June 17, 2024

Re: White Barn – Chick-fil-A – *Technical Review 2*  
PA23019

After reviewing the application materials for the above referenced proposal, the following technical review comments are provided below.

EXTERIOR ELEVATIONS

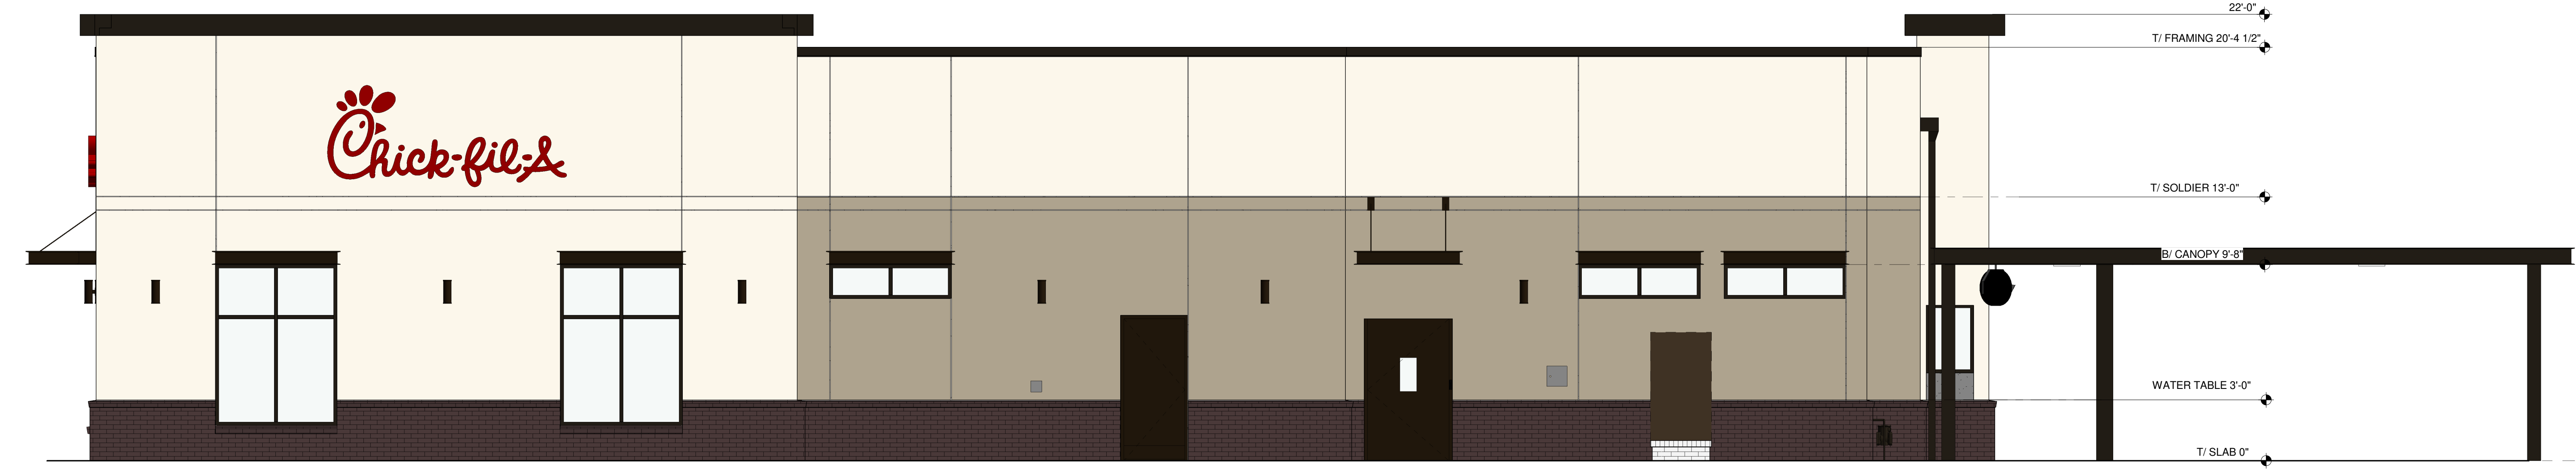
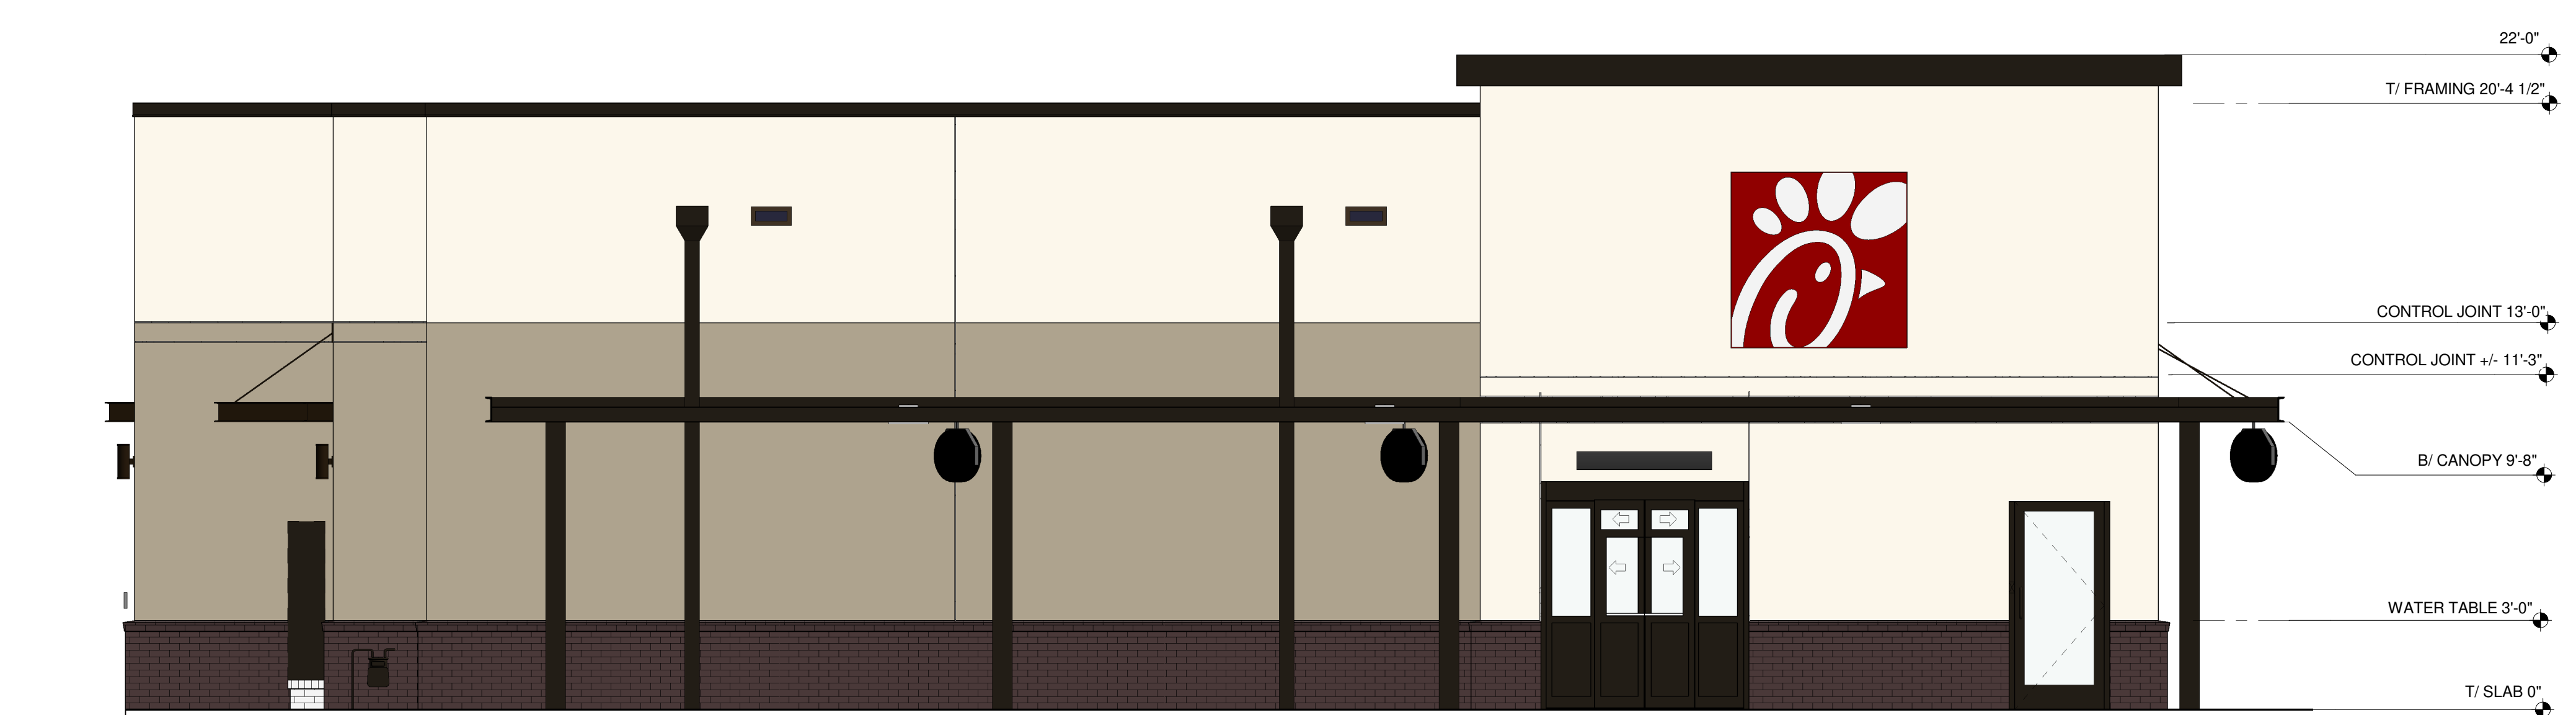
- All fencing, walls and other features used for screening purposes shall be kept free of litter, debris, and weeds.
3. Please provide color elevation drawings of both the restaurant and screen wall for director review and approval related to the reduced landscape setback along 87<sup>th</sup> Avenue NE & Soper Hill Road. This can be submitted as part of the civil and building plan review.

# PRELIMINARY SITE PLAN FOR CHICK-FIL-A MARYSVILLE

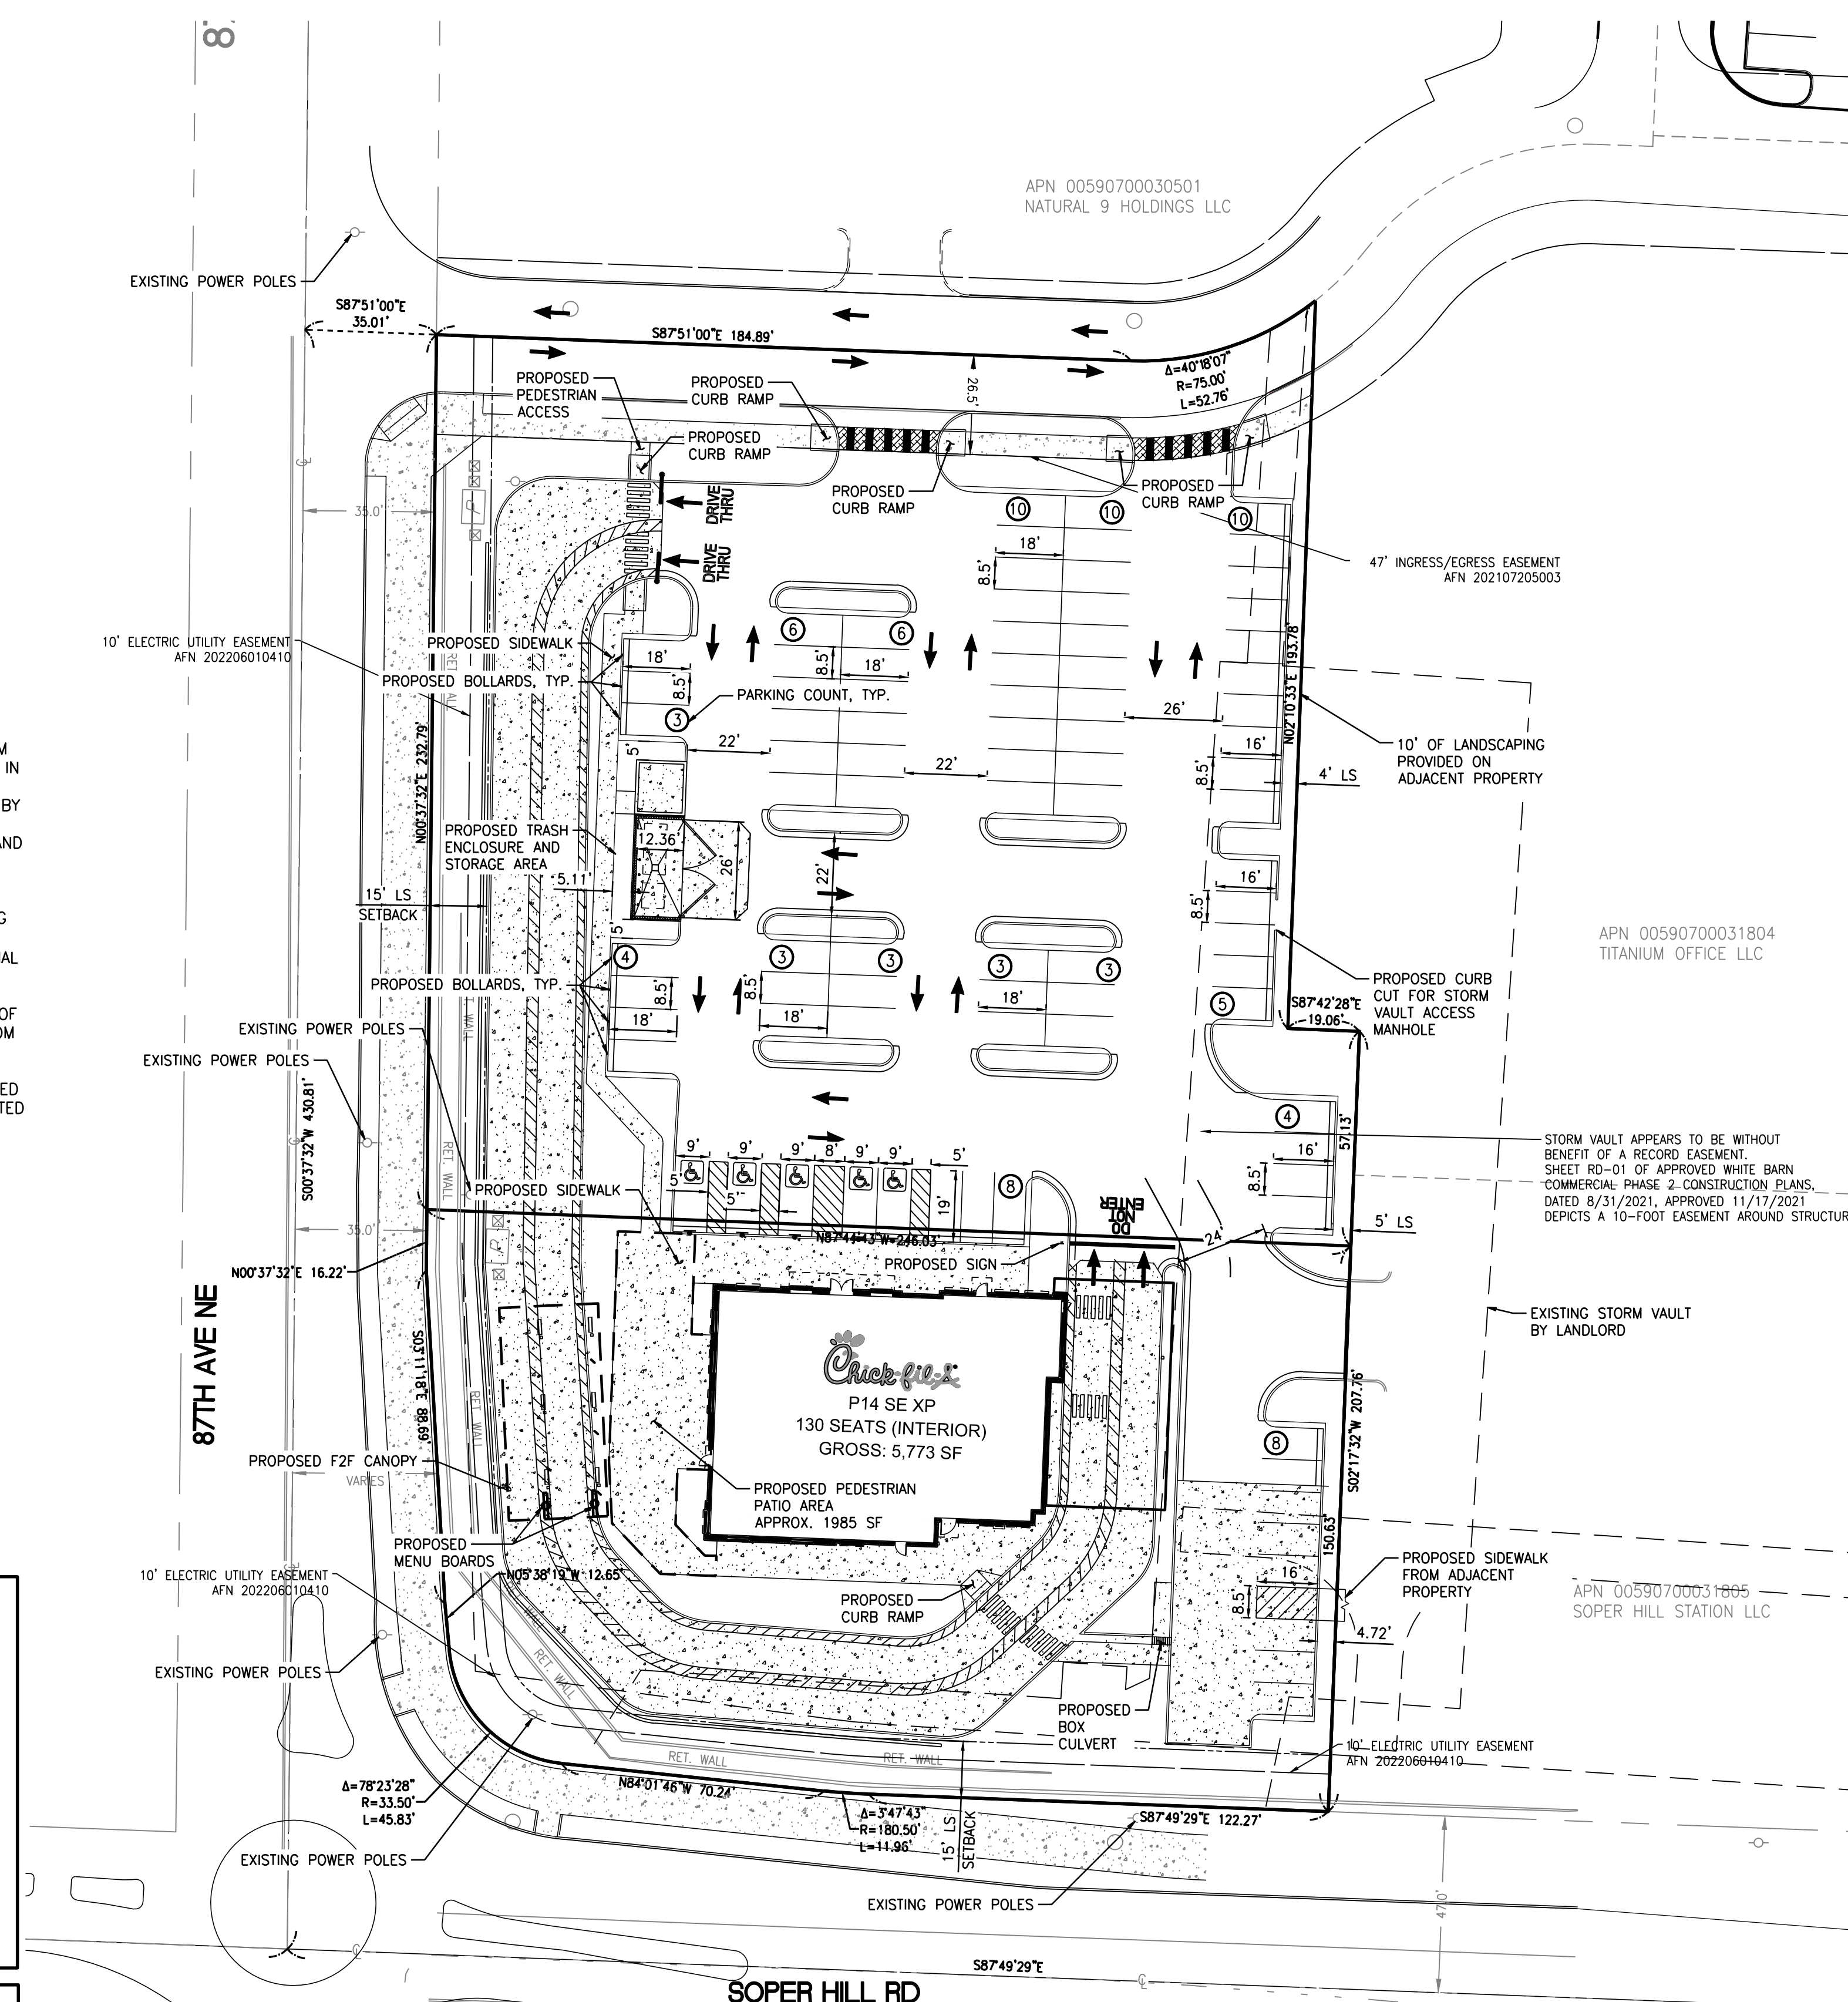
1. Screening along both 87<sup>th</sup> Avenue NE & Soper Hill Road, does not comply with the L2 landscaping standards, and is disapproved, as proposed.

2. As noted in Comment No. 1 above the proposed landscaping does not comply with the provisions outlined in [MMC Chapter 22C.070 East Sunnyside – Whiskey Ridge Subarea – Design Requirements](#). The landscape plan shall be amended, as follows:

- a. An L2 landscape buffer on the south and west perimeters between the street and drive-through is required.
  - b. Provide parking lot landscaping calculations. 10% of the required parking areas shall be landscaped with L4 landscaping. This excludes required perimeter buffers.

- c. Provide the following notes:
    - Utility meters, electrical conduit, and other service utility apparatus shall be located and/or designed to minimize their visibility to the public. If such elements are mounted in a location visible from the street or pedestrian pathway they shall be screened with vegetation or by architectural features.
